Growth, Planning and Trading Standards
Business and Environmental Services
North Yorkshire County Council
Northallerton
DL7 8AH

Your ref: Drax Repower Project
Our ref: 151018 Drax Landscape Strategy
Date: 15 October 2018

Outline Landscape and Biodiversity Strategy V002 – Comment for Landscape and Biodiversity

Figure 6.7.1: Compensation Areas Overview Plan

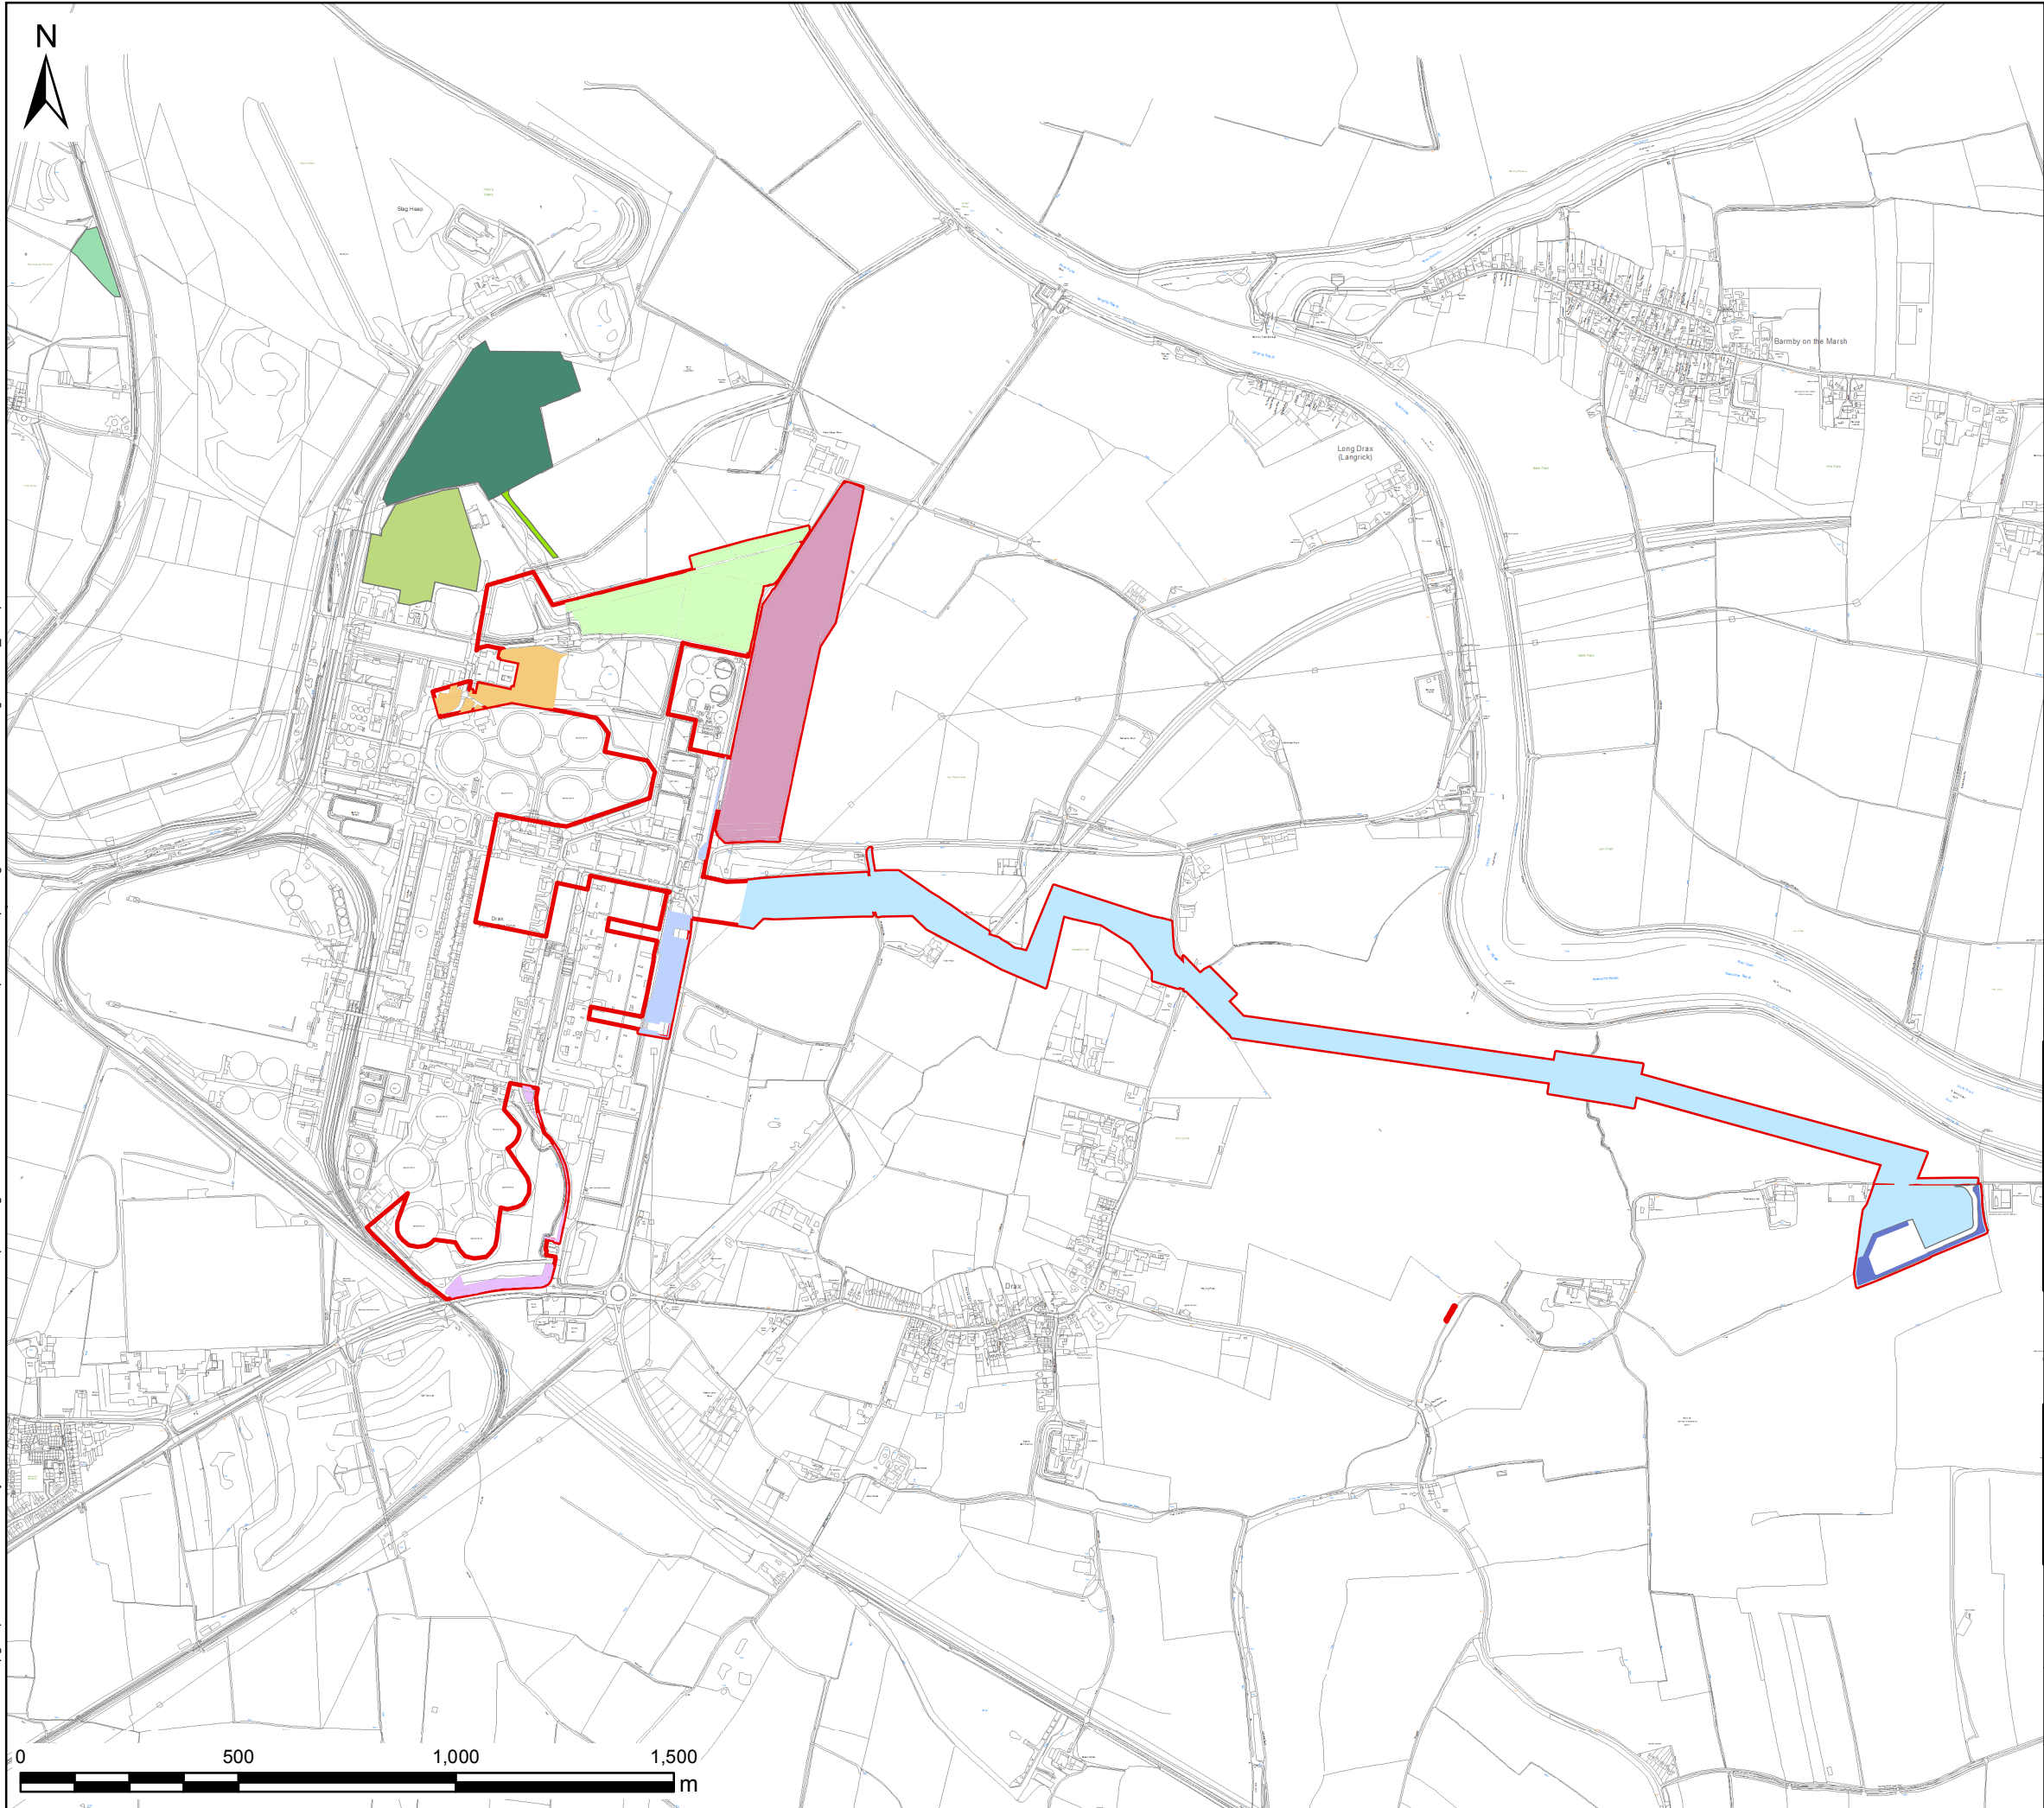
Our overall impression is that the ‘Strategy’ is too heavily focussed on optioneering a select number of sites, rather than on need and how it can be achieved, or a review of the wider options to compensate by improving green infrastructure. The optioneering table is overly negative focussing on commercial interests and justifying what cannot be achieved, when it should be about investigating positive opportunities for landscape and biodiversity mitigation, compensation and enhancement.

From a biodiversity perspective, the commitments within land parcels in the strategy are considered suitable; however undertaking enhancement measures in the wider area would provide a different suite of benefits in terms of habitat connectivity. The last biodiversity net gain report showed a large net loss of linear features including hedgerows. The revised strategy is not accompanied by an updated net gain report and as such it is not clear to what extent this has been addressed and therefore what further compensation or enhancement measures may be required in the wider area.

Further work is needed to identify wider opportunities to reduce significant effects.
